Engineers Comments Regarding Surface Water Drainage

Application Reference:	P/69/26/DOC	Reviewer Reference:	ADC/EXT2/D2134/109
Planning Officer:	Simon Brooksbank	Date of Review:	07.09.2026
Site Name:	Land North of Sefter Road & 80 Rose Green Road Pagham		
Application Description:	Approval of details reserved by condition under P/134/16/OUT relating to condition 10- Surface Water Drainage.		
Assessment Number:	2

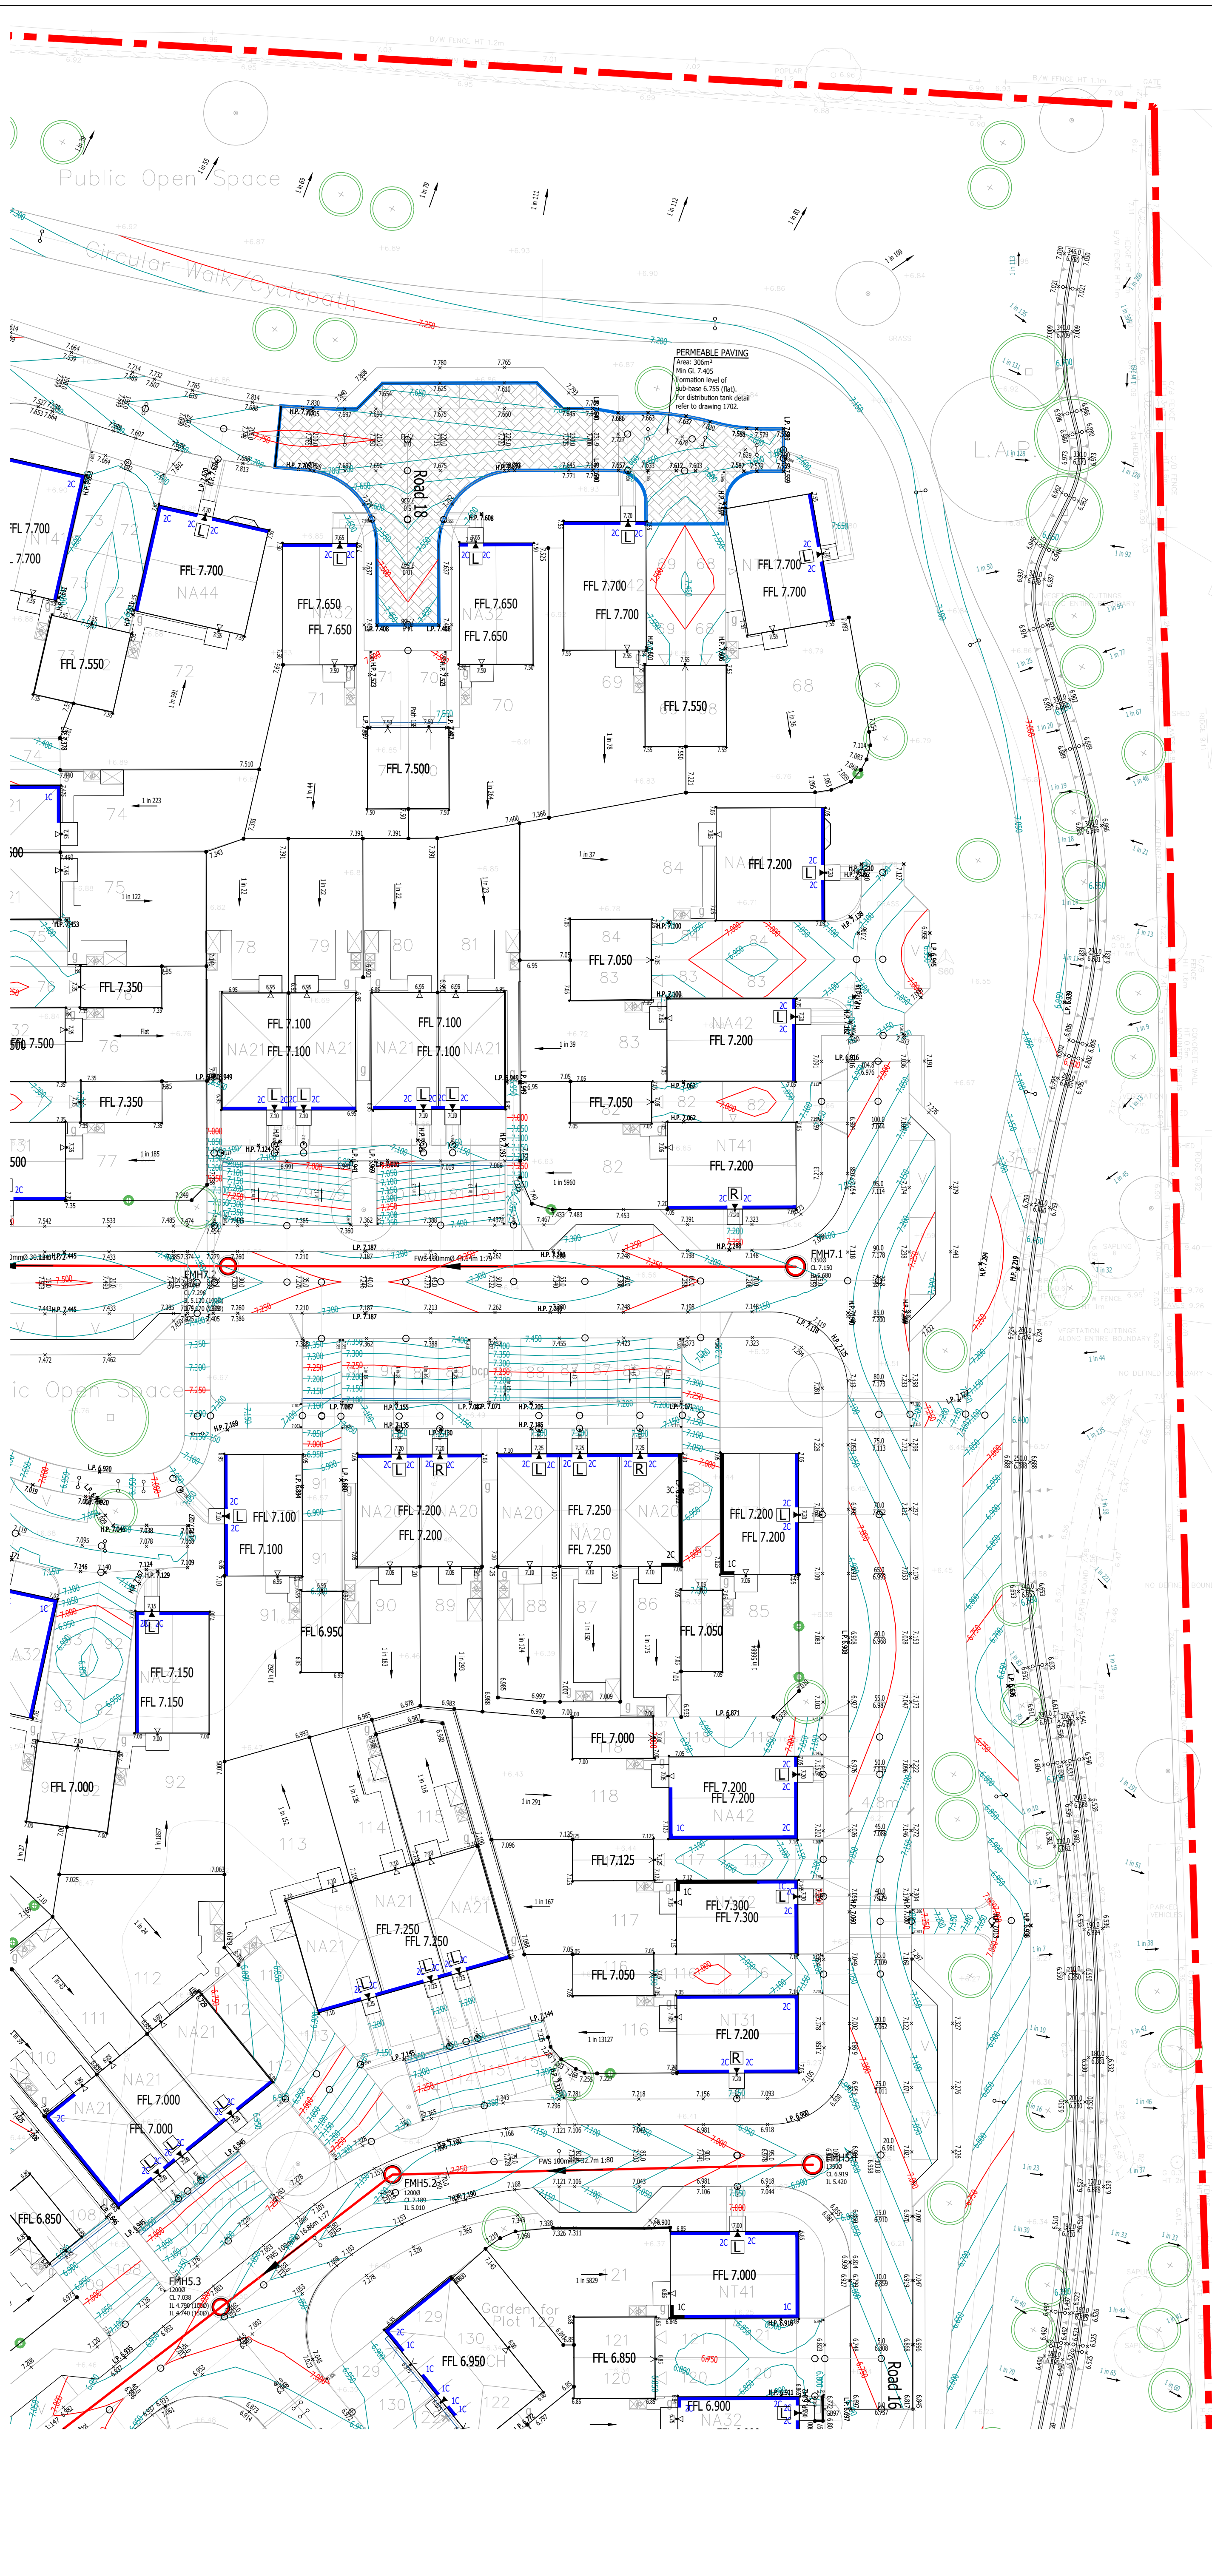
6.		Further to comment 4 above, it is evident that the flood bunds and swale are to provide some mitigation for exceedance flow. Further evidence is require to determine the impacts of these local catchments where this is partially footway (impermeable) and verge (greenfield run-off). This shall be quantified and re-modelled within the 1D calculations to conclude there is sufficient provision within the receiving SUDS basins/network.	The surface water run off is minimal yet as a precautionary measure to appease concerns of the neighbours abutting the site we have worked with our engineer to amend the drainage design to manage the concern. Calcs can be provided if necessary following conformation with Paul Cann that this is satisfactory solution following the site visit.	Noted. It is noted a Scalgo analysis has been provide for post & pre development scenarios, however the impacts cannot be assessed without further data. In addition this shows some existing dwellings to the east where ponding appears worse. Can this be further evidenced? In order that this features is suitably documented, please provide a engineers statement together with supporting calculations as previously requested. Comment outstanding.
